**From:**  
**To:** [DCAdmin](#)  
**Subject:** Application 2020/93700  
**Date:** 08 January 2021 16:08:21

I refer to the planning application 2020/93700, which relates to the land adj 47 Cresswell Lane, Heckmondwike.

Title Proposed Elevations
 HOUSE 2

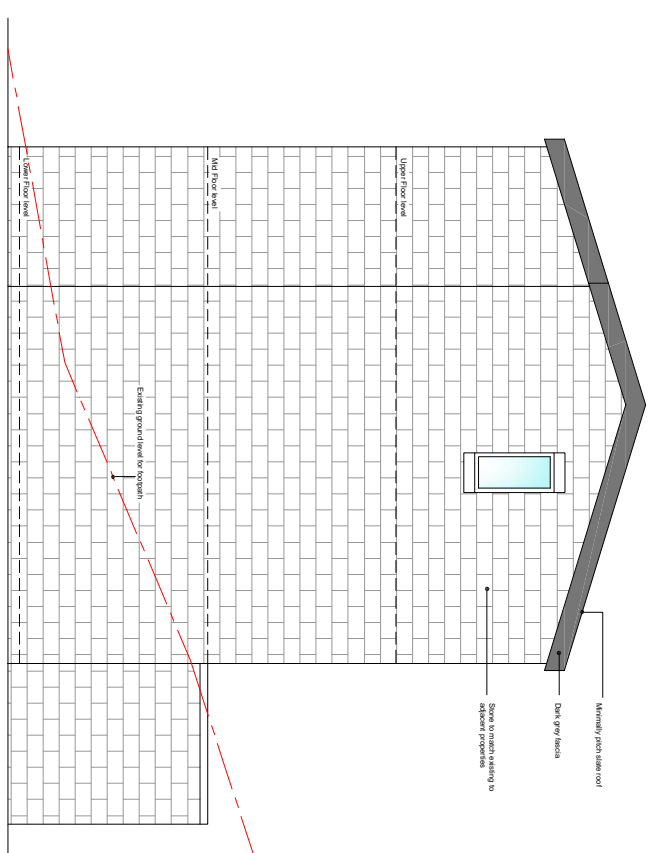
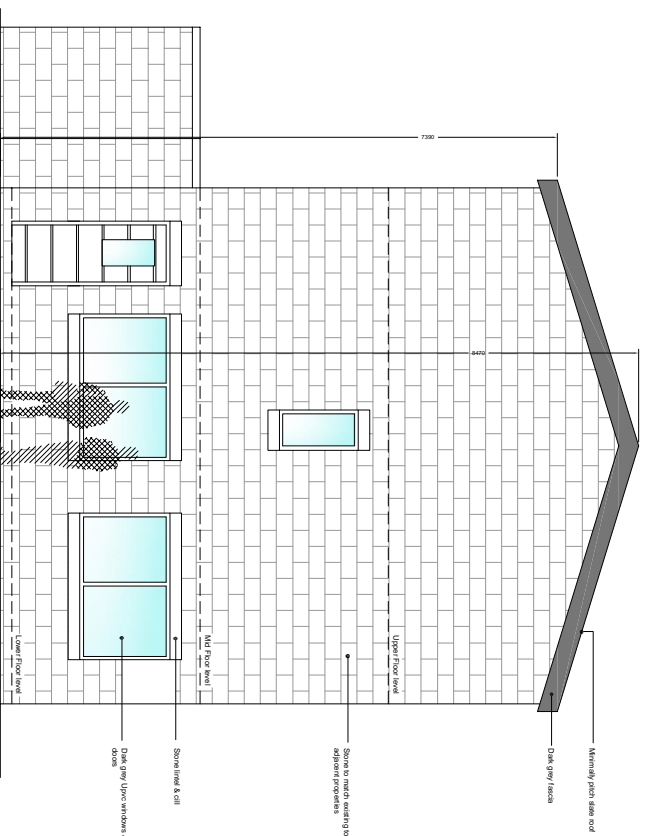
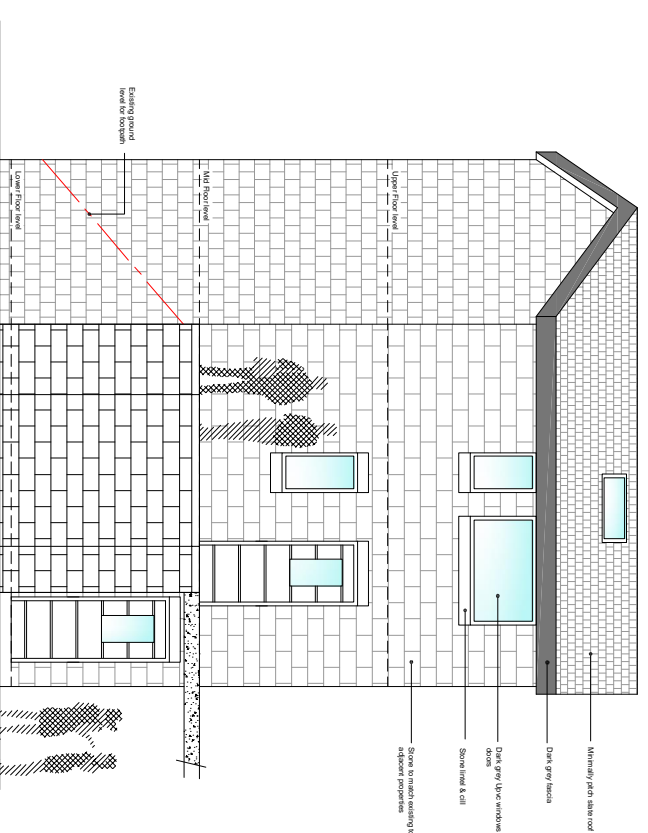
The smaller of the two house(house number 2) would cause some significant privacy issues due to the proximity, from the draws the level of the house would mean that they would be at the same level from their window as my upstairs windows,

It also appears that the 2nd house would also tower above my property, this would block the only light source at the top of the stairs from reaching the bottom of the stairs creating even more anti social problems which we regularly get along this path. This would also be the case for my neighbours

Can I also bring to the attention that it appears the plans showing on your site do not show all the levels for house number 2, it only appears to be one level yet there are stairs going to a "mid level", and appears on some diagrams having a garage, yet it does not show how they would gain access to this.

Title Existing Site Plan

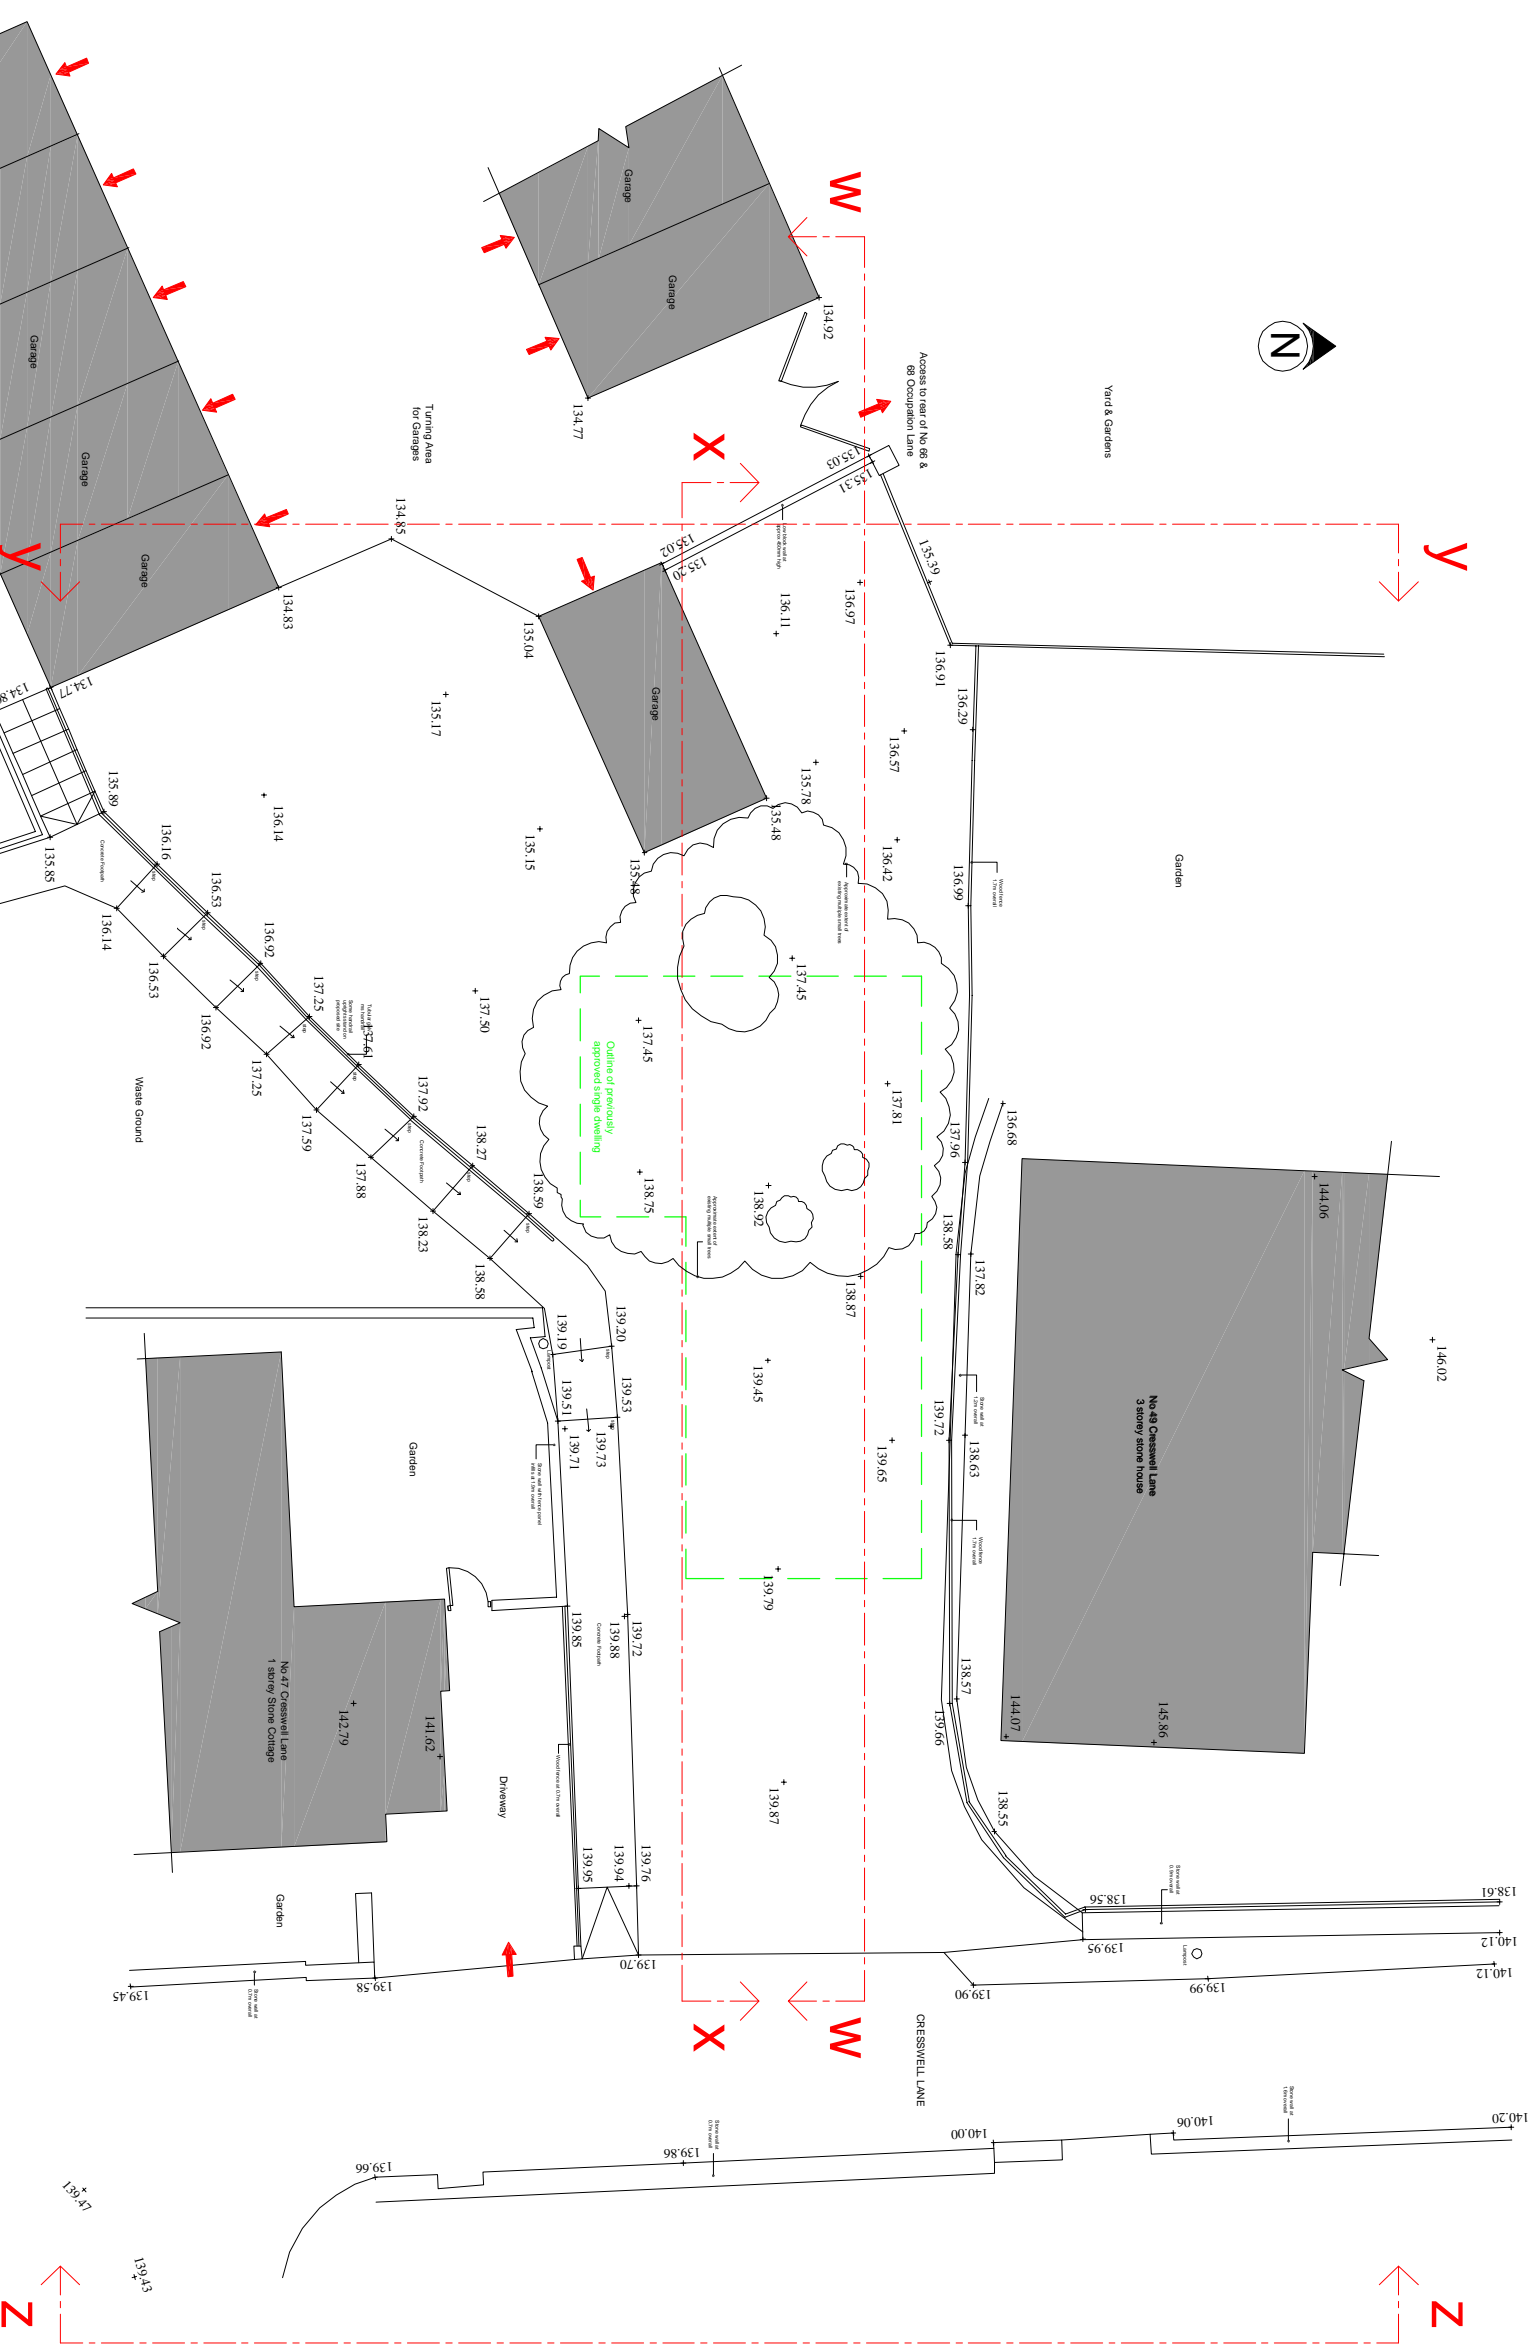
The plans also show "waste ground" at the side of the plot to the rear of mine, this is not waste ground but its part of my property which will be developed later this year to a usable garden area. This would mean my garden at its highest level would be looking in to the properties.
